**Submission by Residents Opposing Lavender Bay Overdevelopment
5 Blue Street, North Sydney – SSD-86270706**

9 August 2026

1 PLAN Plaza Section (E-W)
1:100

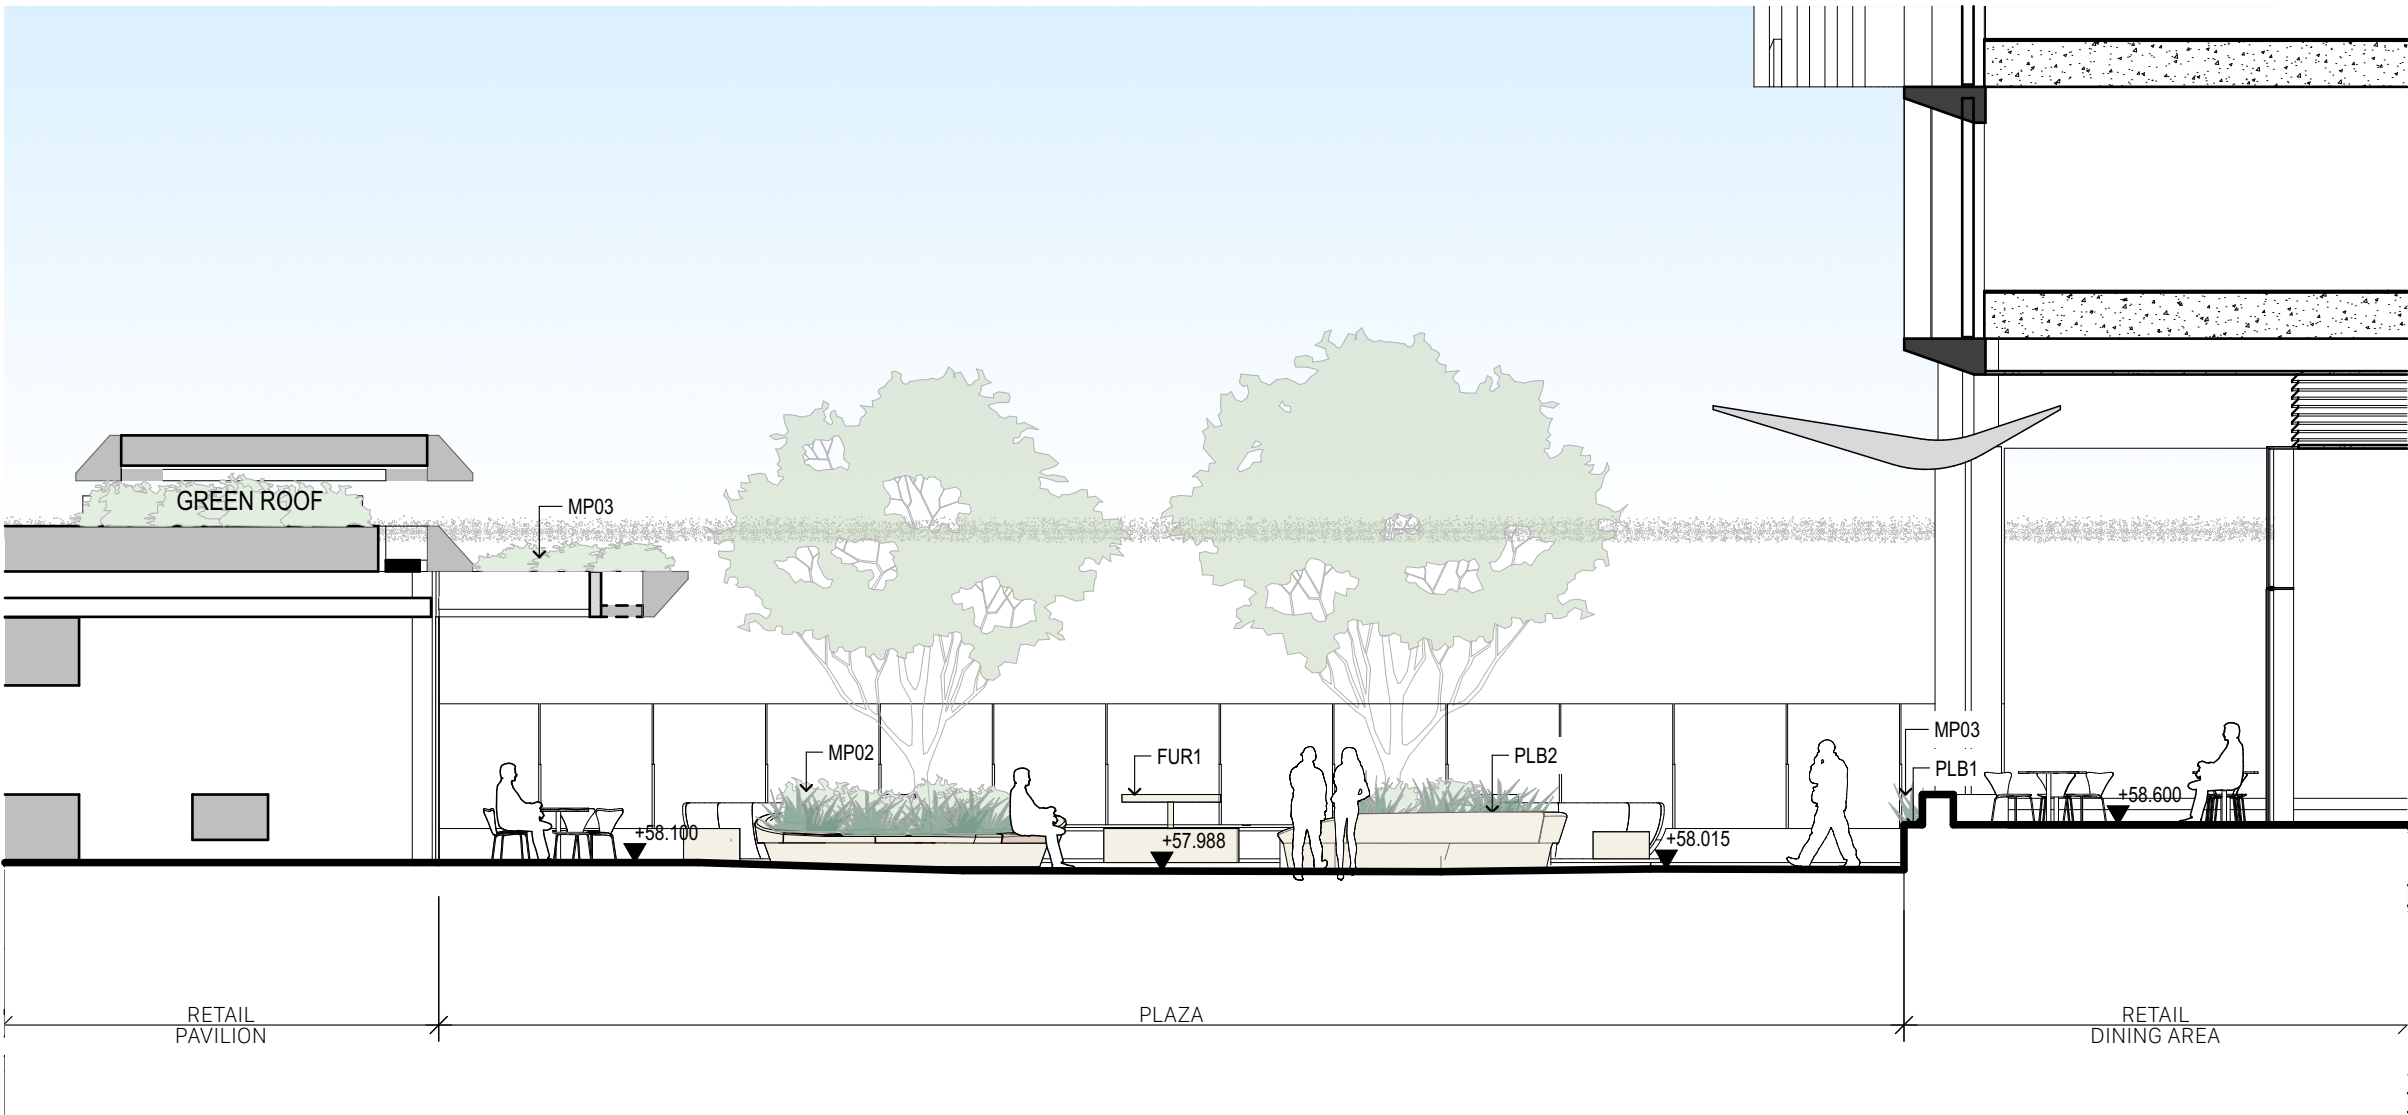
ROLBO is sorry to see the extent to which the proposed residential floors cantilever eastwards over the existing Blue Street Plaza.

The applicant's plans show that the eastern residential floorplate would extend approximately 3.6 metres further towards the plaza than the existing building condition. The Architectural Design Report describes these eastern cantilevers as “essential to project feasibility”, allowing apartments to be oriented towards harbour views rather than directly towards 15 Blue Street.

The cantilever will inevitably change the experience of this open-air space. What is currently an open plaza with sky and harbour outlook will, in part, have a substantial residential building projecting above it. In ROLBO's view, this risks creating a **“lid” over part of the plaza**, increasing enclosure and shadow and detracting from the sense of openness that makes the space valuable.

If there is an opportunity to reduce the extent of the eastern cantilever while retaining a viable adaptive-reuse scheme, ROLBO would be hugely supportive of this being explored. Even a partial reduction could preserve more sky, light, openness and outlook from the plaza while retaining the considerable benefits of the overall proposal.
